H2Teesside Project

Planning Inspectorate Reference: EN070009

Document Reference: 7.11 Second Change Application Report

Date: February 2025

Sheet 1 of 18 (Change 1)

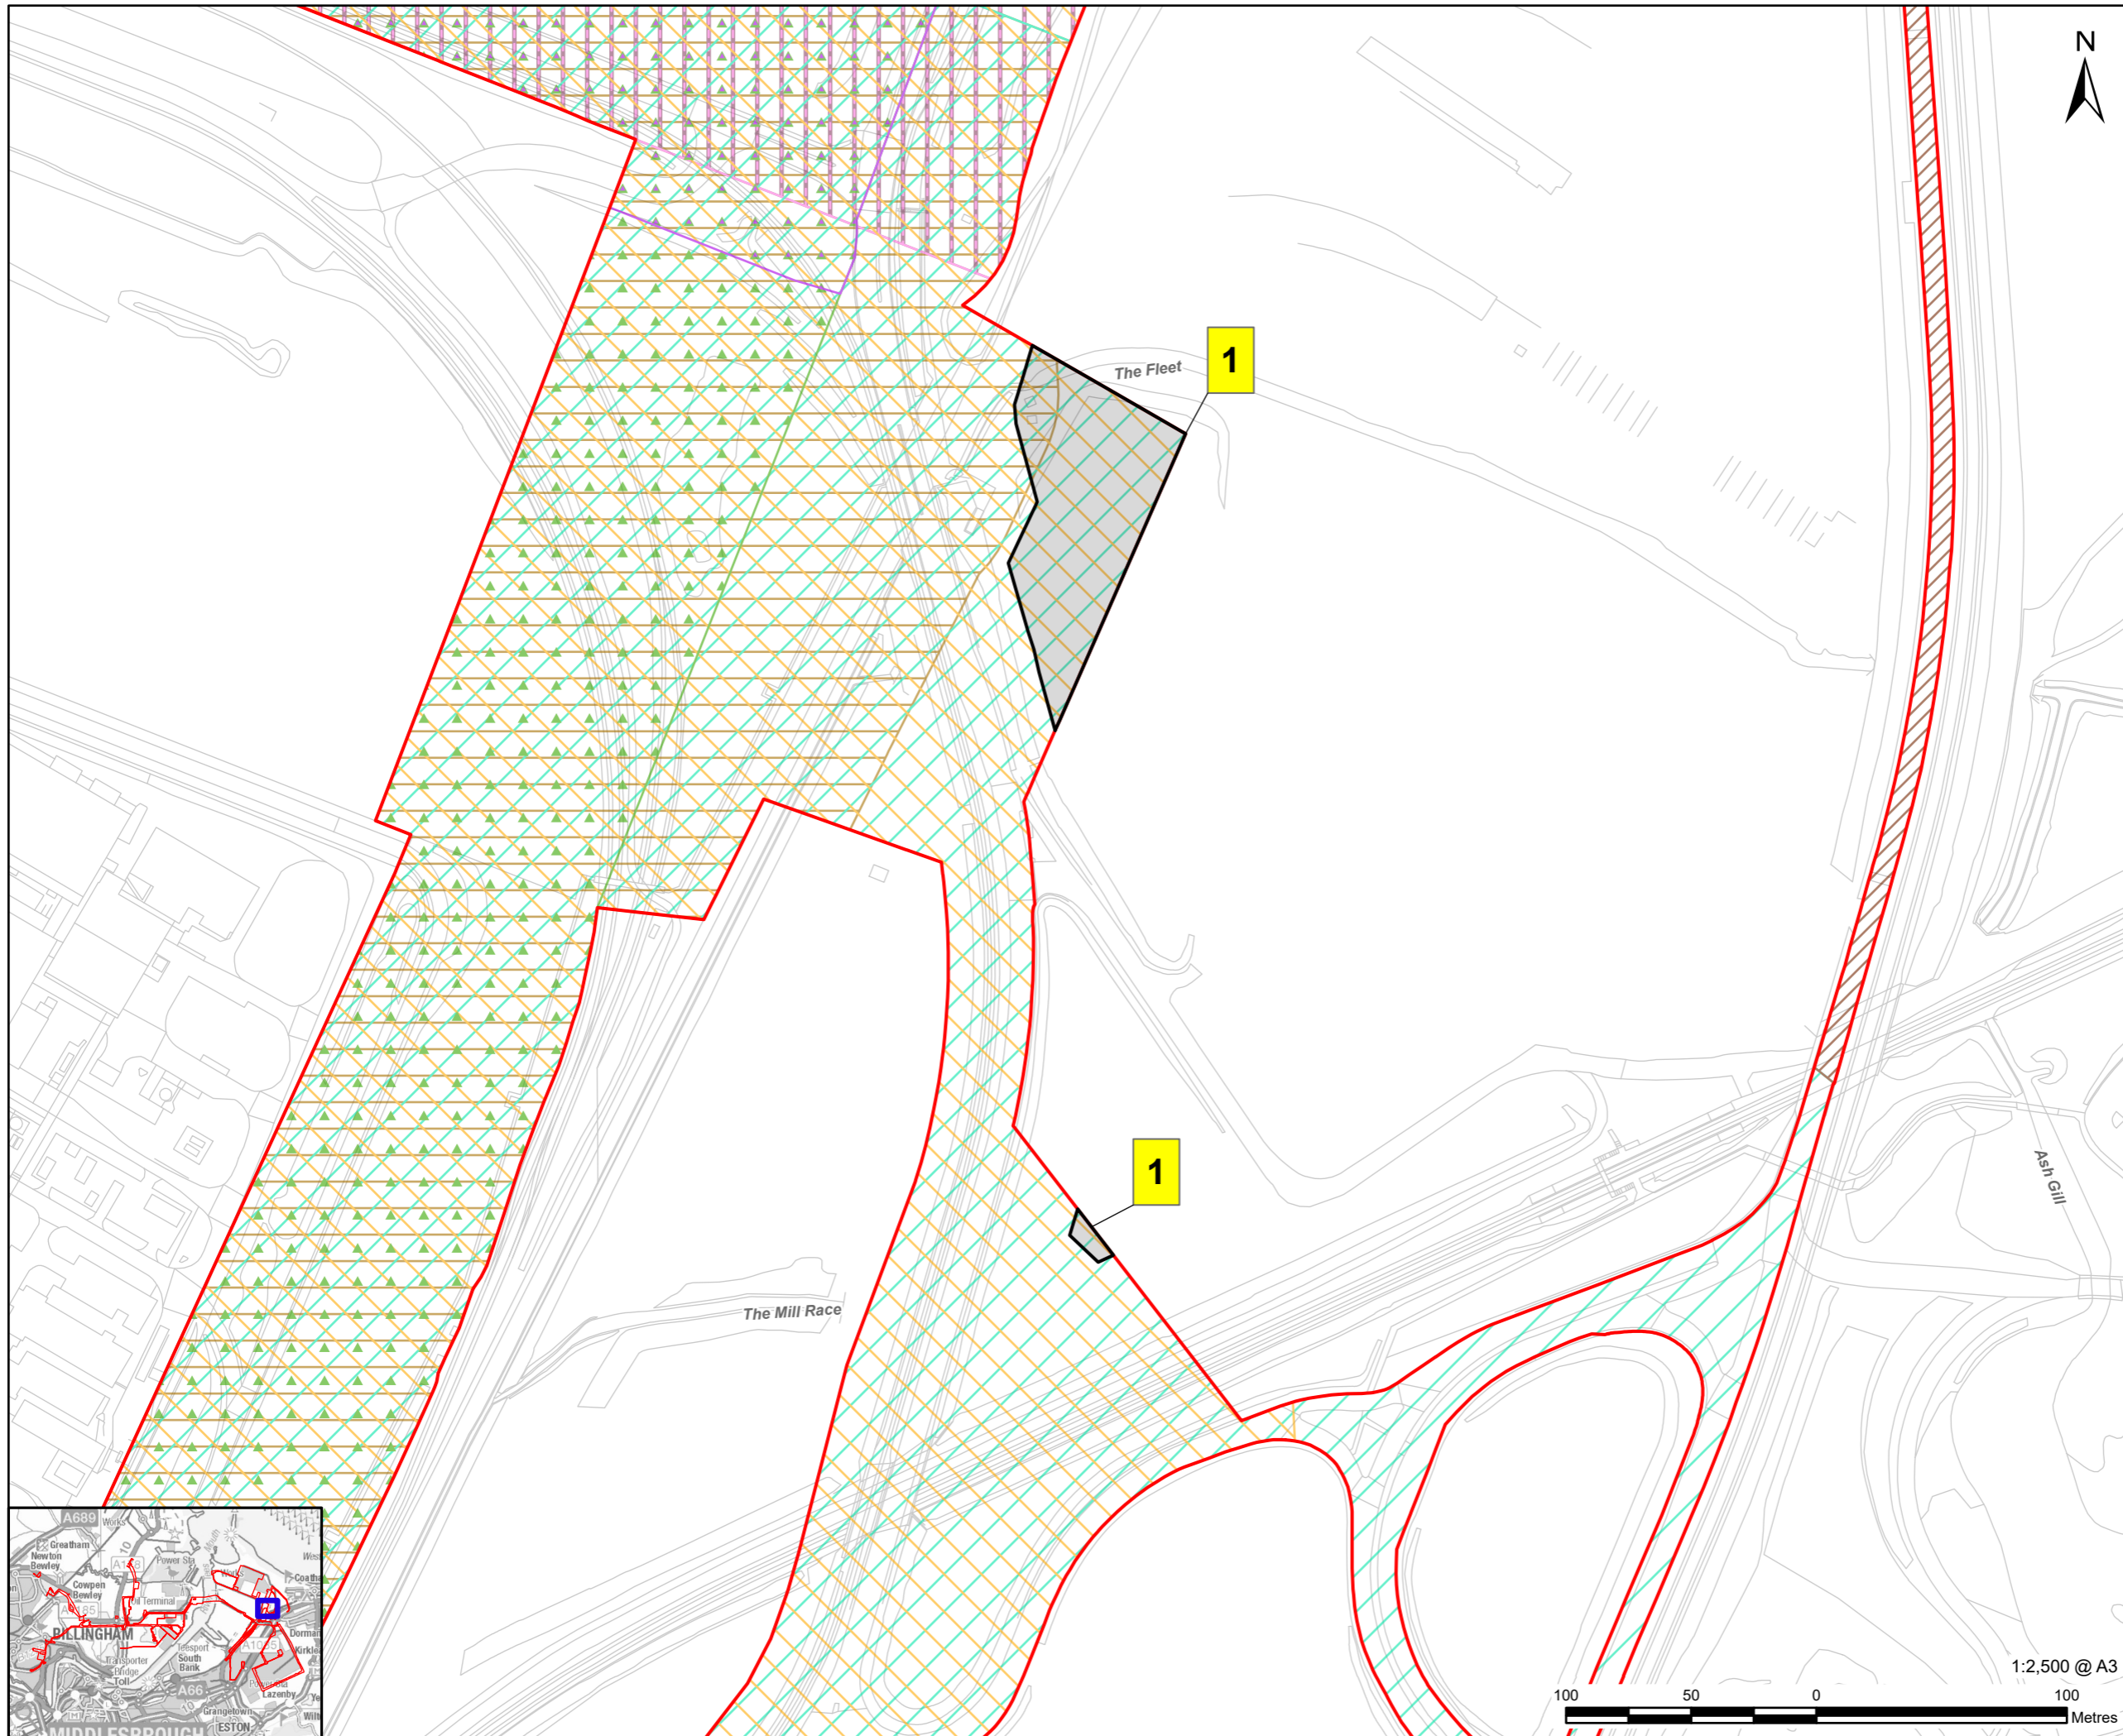
Change 1 – Overlap with the proposed NatPower BESS Site, east of the Main Site

- 2.2.4 A change is proposed in this area as a result of the Examination submissions of South Tees Group ('STG'), who have brought to the Applicant's attention a planning application by NatPower UK for a Battery Energy and Storage System ('BESS') project to the east of the Main Site.

- 2.2.5 Currently, the Order limits for the Proposed Development slightly overlap with the western edge of that development. Following discussions with STG and in the spirit of co-operation, the Applicant has agreed to reduce the flexibility sought in relation to the construction of its project in this area and remove the areas of overlap from the Order limits.

- necessitates a slight reduction in size of plots 15/34, 15/35, 15/36 and 15/166 of the Land Plans (also reflected in the Book of Reference);
 - necessitates the removal of Work No. 3 (power supply connection) on Sheets 12 and 13 from the Works Plans at these locations, Work No. 6A.1 (hydrogen pipeline) on Sheets 22/23, and Work No. 8 (oxygen and nitrogen connections) on Sheet 26, from the Works Plans at these locations; but

Sheet 2 of 18 (Change 2)

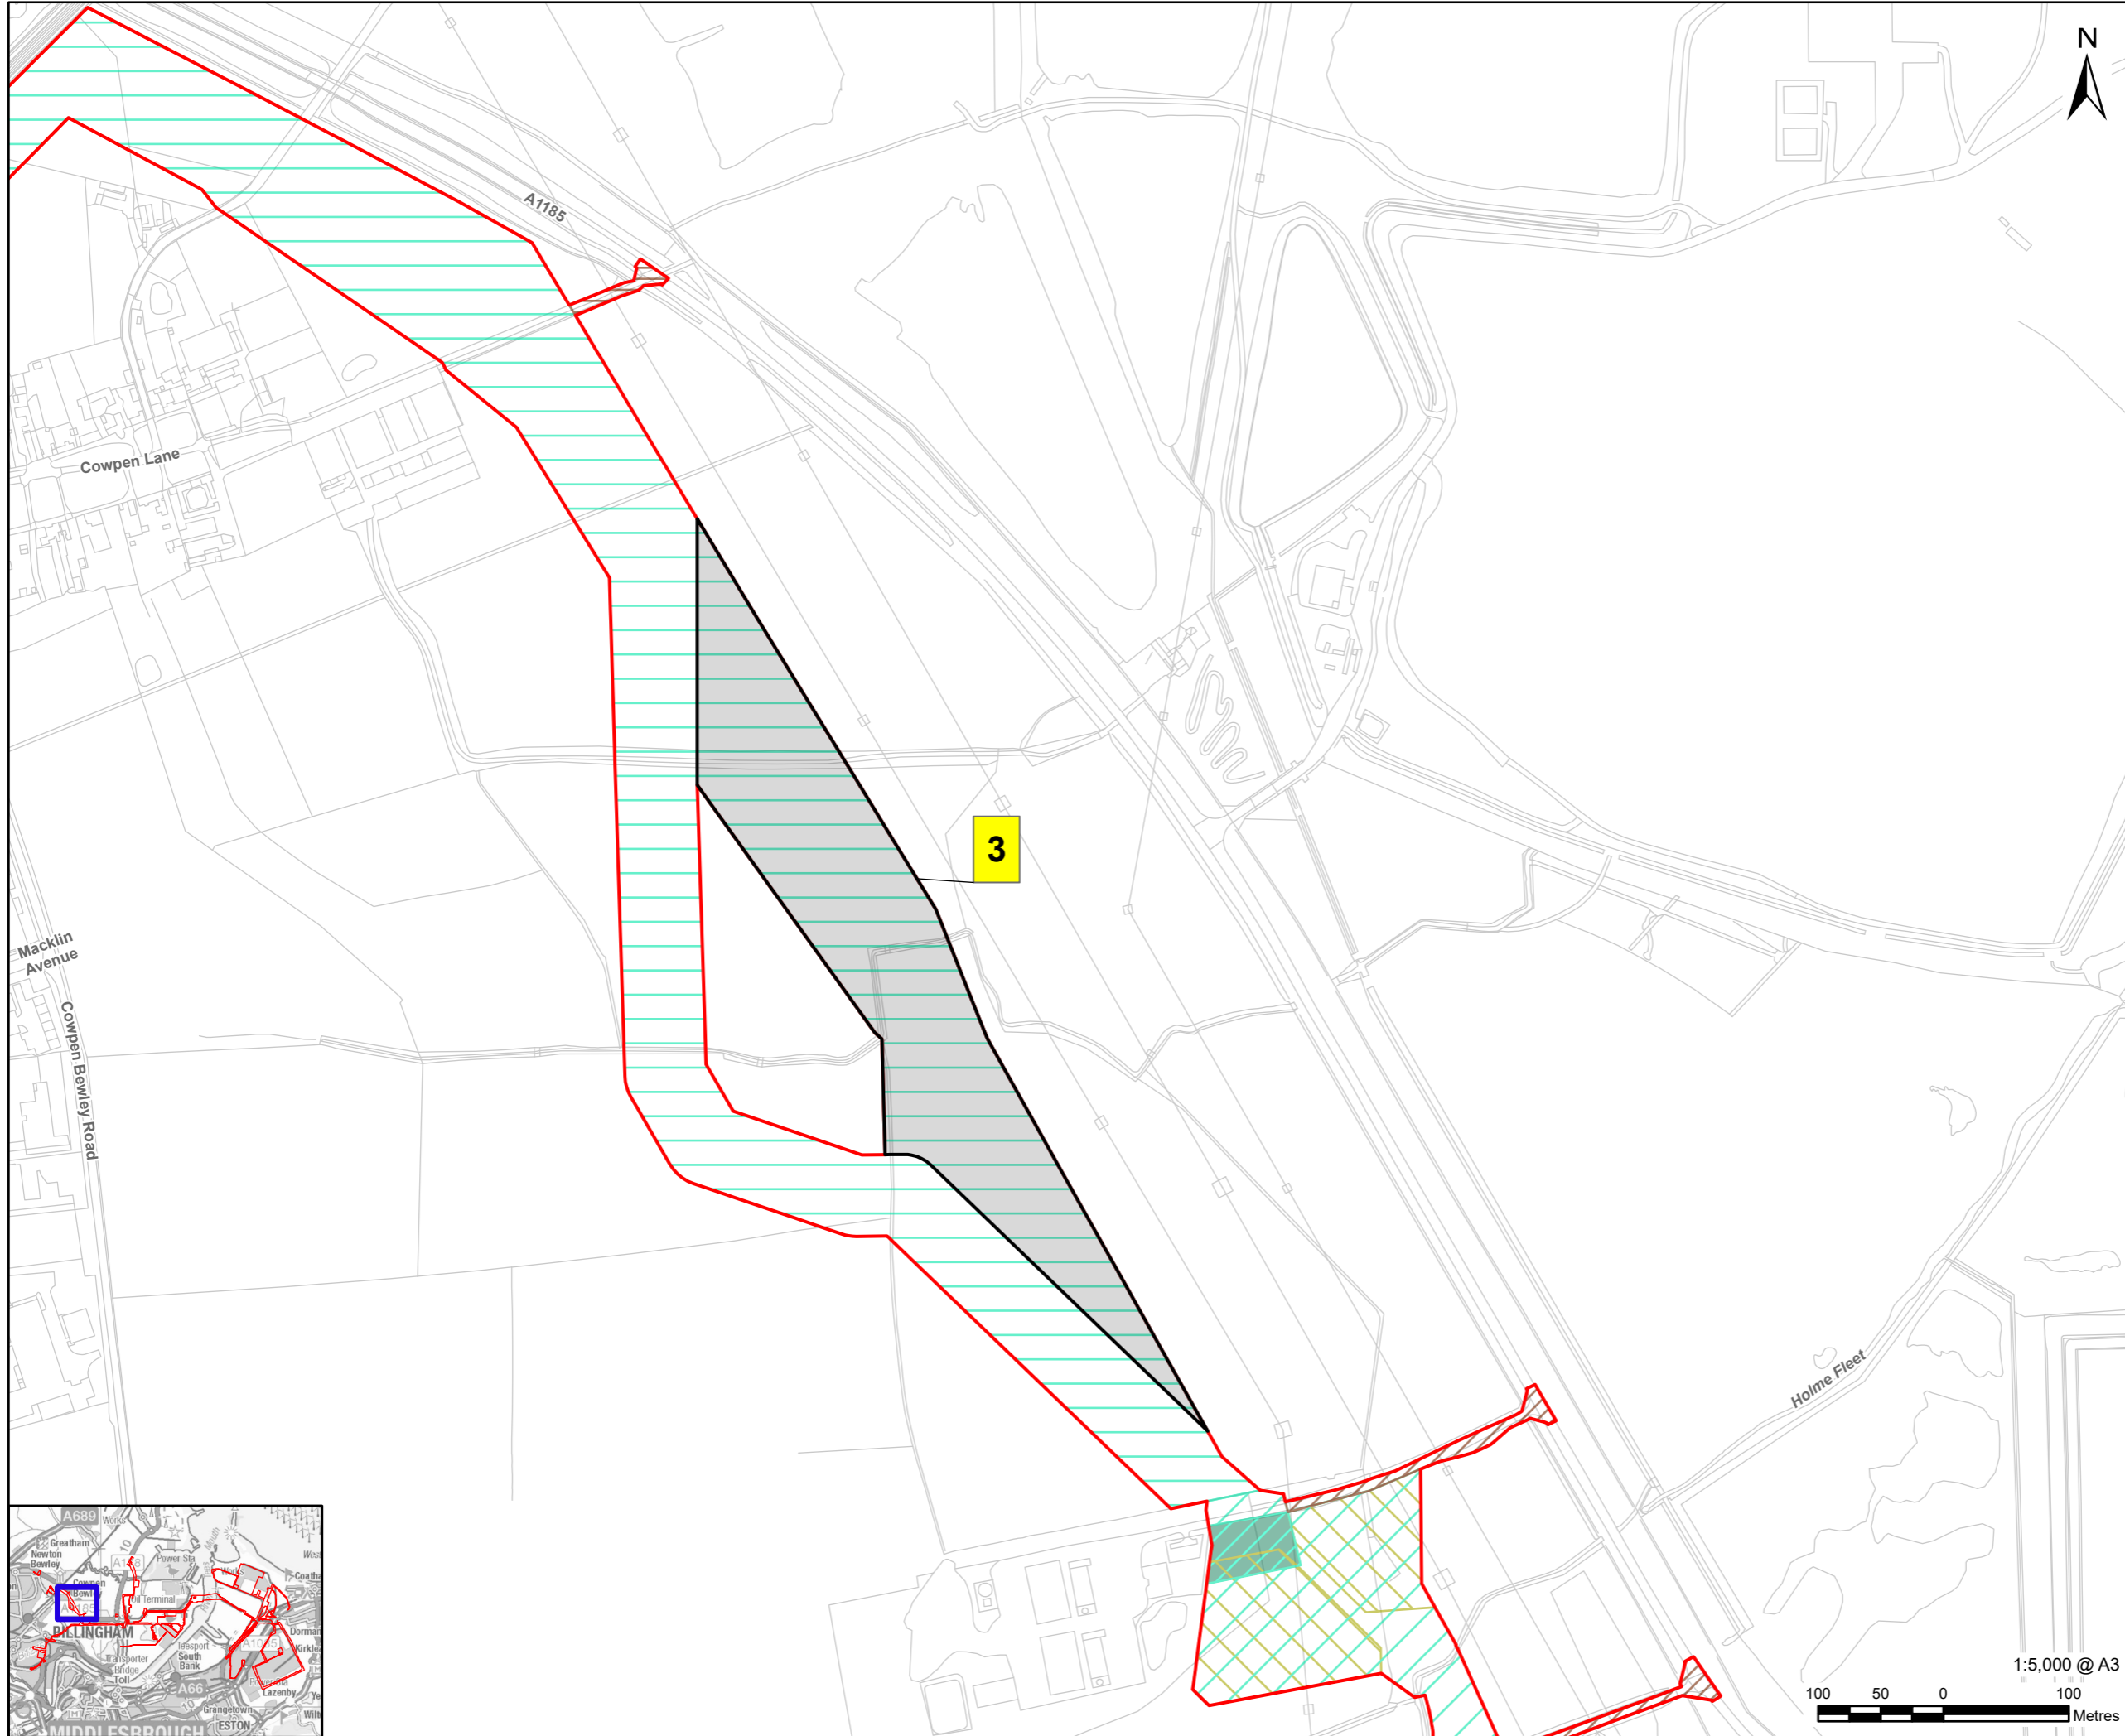
Change 2 – Ineos Nitriles facility, North of Seal Sands Road

- 2.2.8 A change is proposed in this area following engagement with Ineos Nitriles, who were concerned as to the extent of temporary possession within its facility to facilitate the construction of the hydrogen pipeline corridor, in particular the need for staging areas to support the construction of pipe bridges.

- 2.2.9 Following discussions with Ineos Nitriles and a constructability review, the Applicant has agreed that the staging areas can be removed from the Order limits, whilst imposing no impediment to the delivery of the Proposed Development as the adjacent parts of plot 10/24 are sufficient to facilitate the construction of the support infrastructure and pipelines.

- necessitates a slight reduction in size of plot 10/24 of the Land Plans (also reflected in the Book of Reference);
 - necessitates the removal of Work No. 6A.1 (hydrogen pipeline) from those areas from Sheet 20 of the Works Plans; but
